CITY OF ALBUQUERQUE

November 1, 2017

Re: Sandia Acrobatic Gymnastics Academy
3400 Candelaria Rd. NE
Traffic Circulation Layout
Architect's Stamp 10-18-17 (H16D152)

TRAFFIC CIRCULATION
PLAN

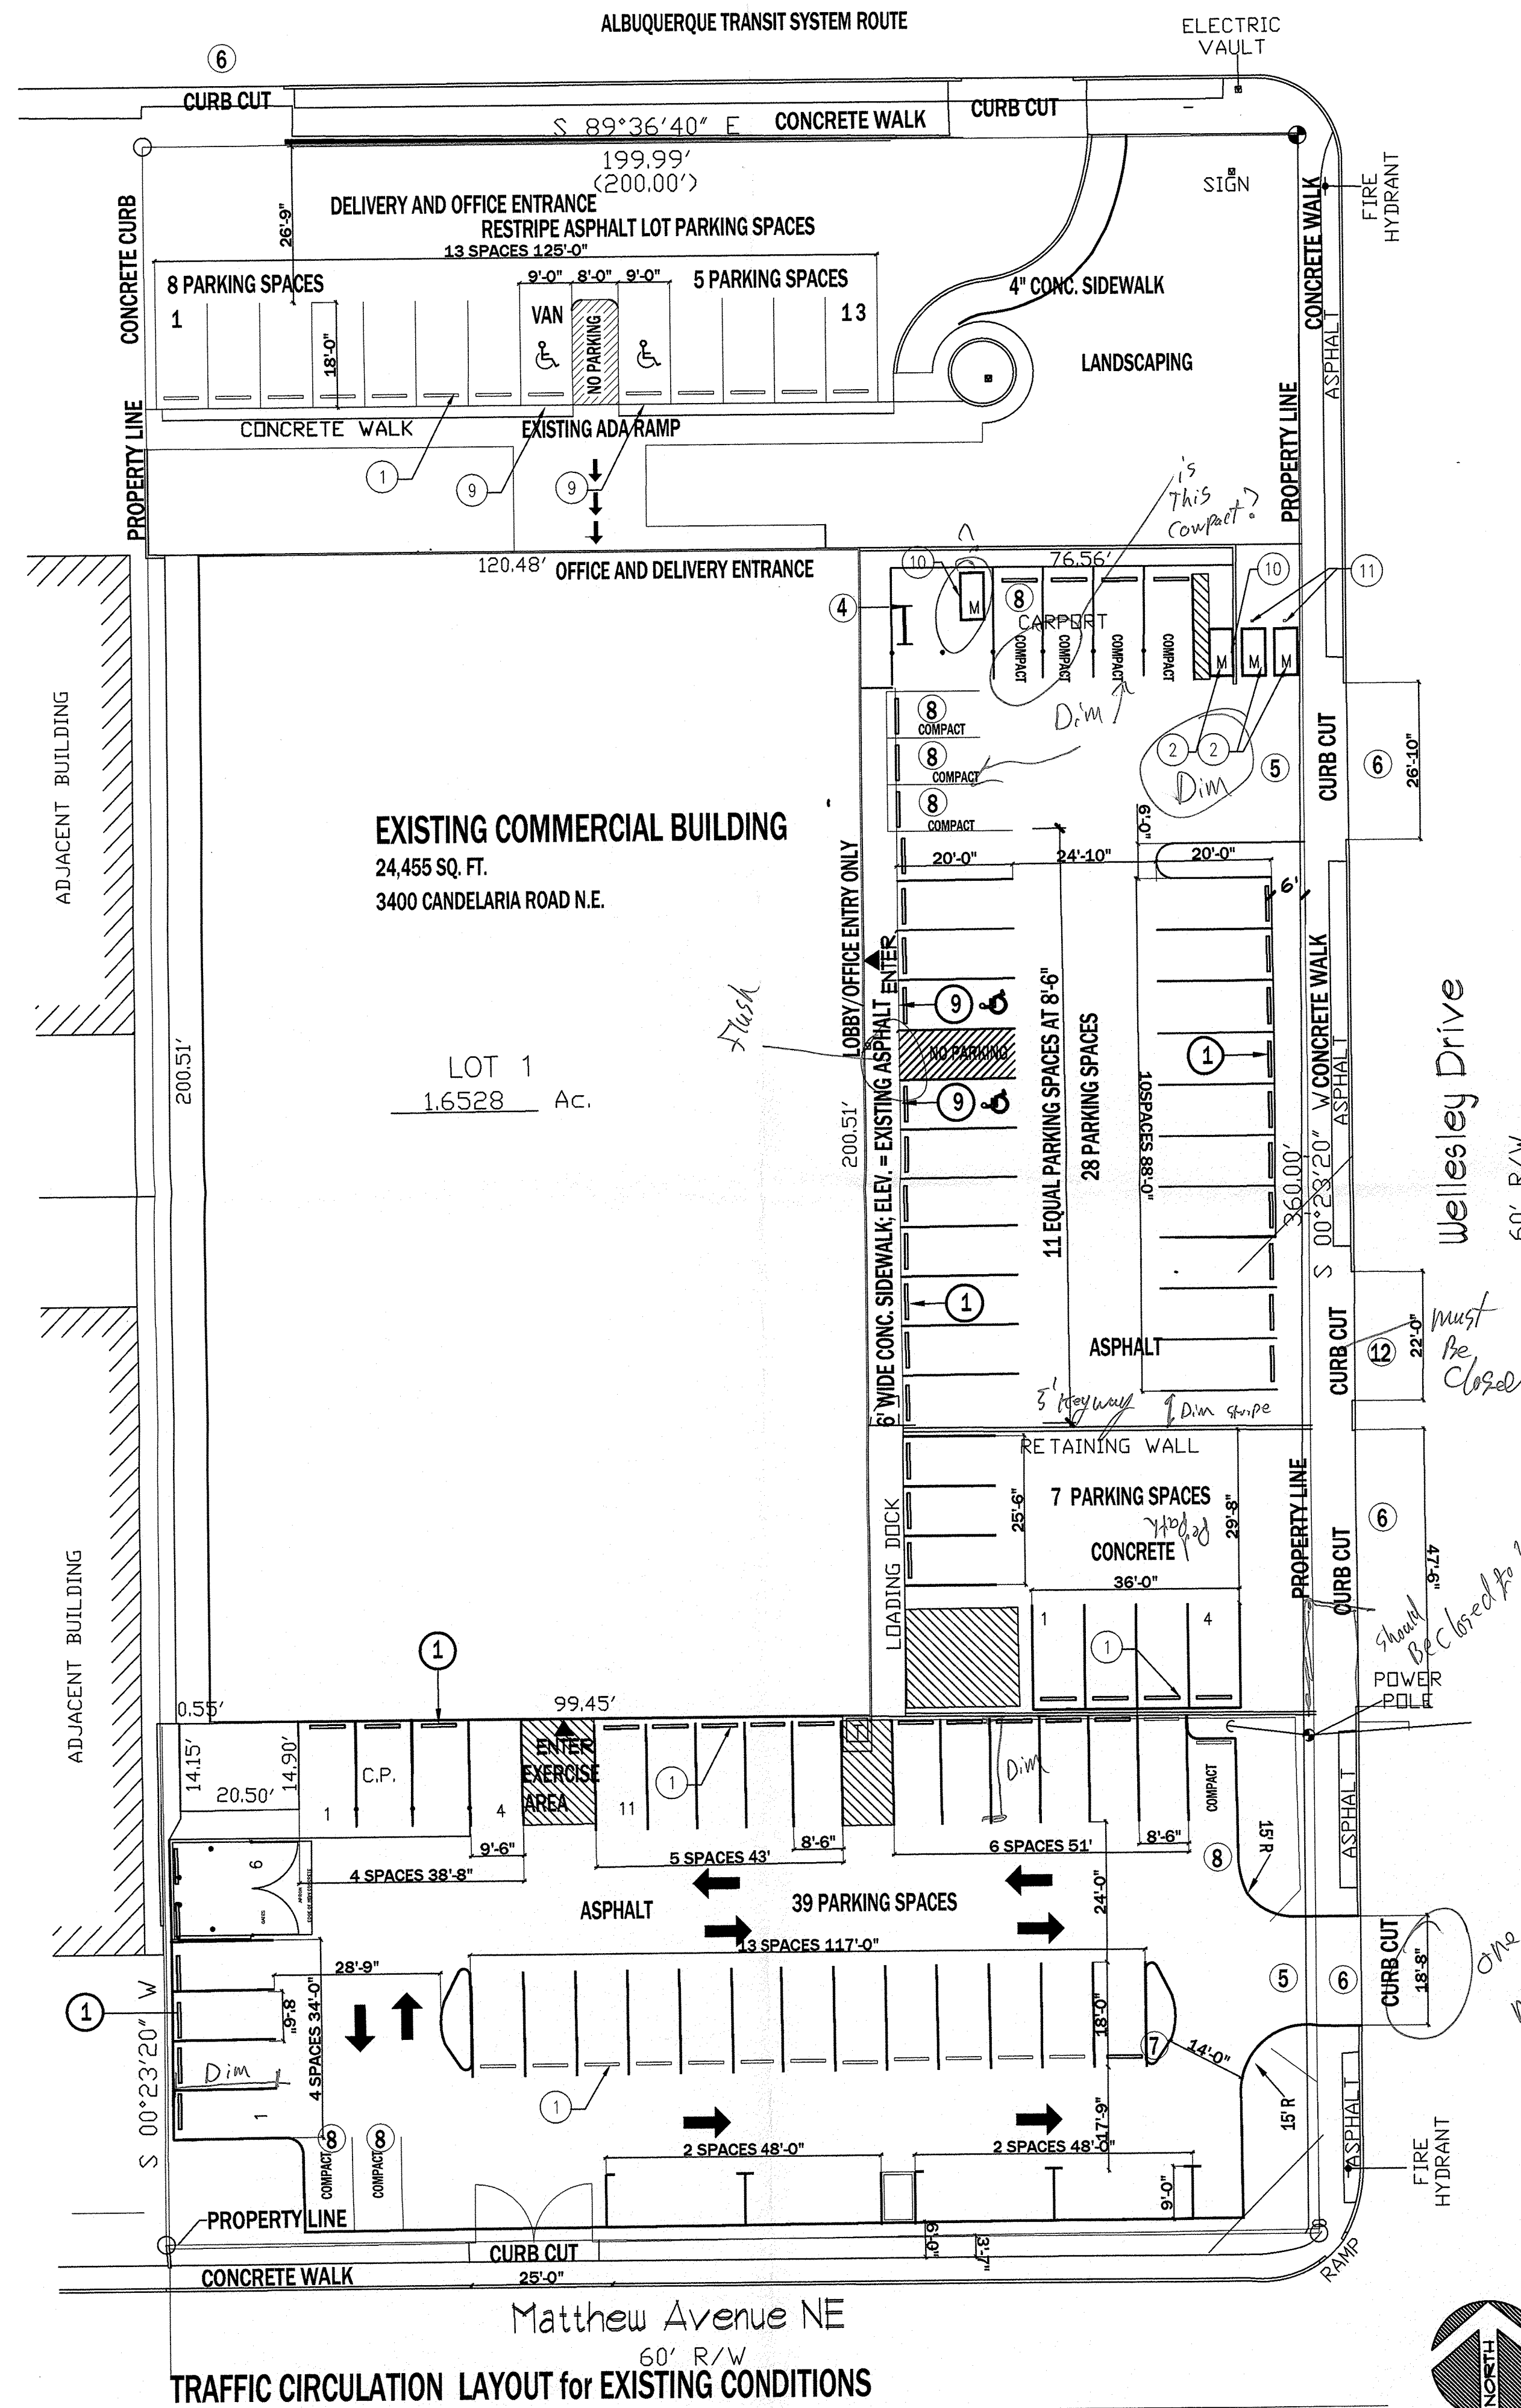
1. Please show a vicinity map showing the location of the development in relation to streets and well known landmarks.
2. Label the compact parking spaces by placing the words "**COMPACT**" on the pavement of each space.

3. Dimension the widths on all drive entrances and parking access aisles some dimensions are not shown.
4. List radii for all curves shown; for passenger vehicles, the minimum end island radius for passenger vehicles is 15 ft. Radius for delivery trucks, fire trucks, etc. is 25 ft. or larger.

5. Per DPM, a 6 ft. wide ADA accessible pedestrian pathway is required from the HC parking stall access aisles to the building entrances. Please clearly show this pathway and provide details. Also show the ADA ramps from the ADA access aisles to the building entrances.

6. Please provide the locations of the ADA signs for the ADA parking spaces.
7. Please define "M" that located on the northeast side of the building.
8. On-Street parking credit to fulfill zoning's parking requirement must be requested and approved by the Traffic Engineer, Racquel Michel prior to TCL approval. The application requires at least 45 working days. On-street parking credit is based on available parking along public right-of-ways fronting the property. The business will only be granted 50% credit for available street parking.

9. Unused curb cuts must be replaced with sidewalk and curb & gutter. A build note must be provided referring to the appropriate City Standard drawing.

10. Motorcycle parking spaces shall be designated by its own conspicuously posted upright sign, either free-standing or wall mounted per the zoning code.
11. The angled parking on the south side of the site looks too small, please follow the DPM for angled parking and provide the angle of the parking space.
12. One-way vehicular paths require pavement directional signage and a posted **"Do Not Enter"** sign at the point of egress. Please show detail and location of posted signs. The access aisles for the parking on the south of the site are too small for two way traffic.
13. Service vehicle and/or refuse vehicle maneuvering must be contained on-site; provide a copy of refuse approval.
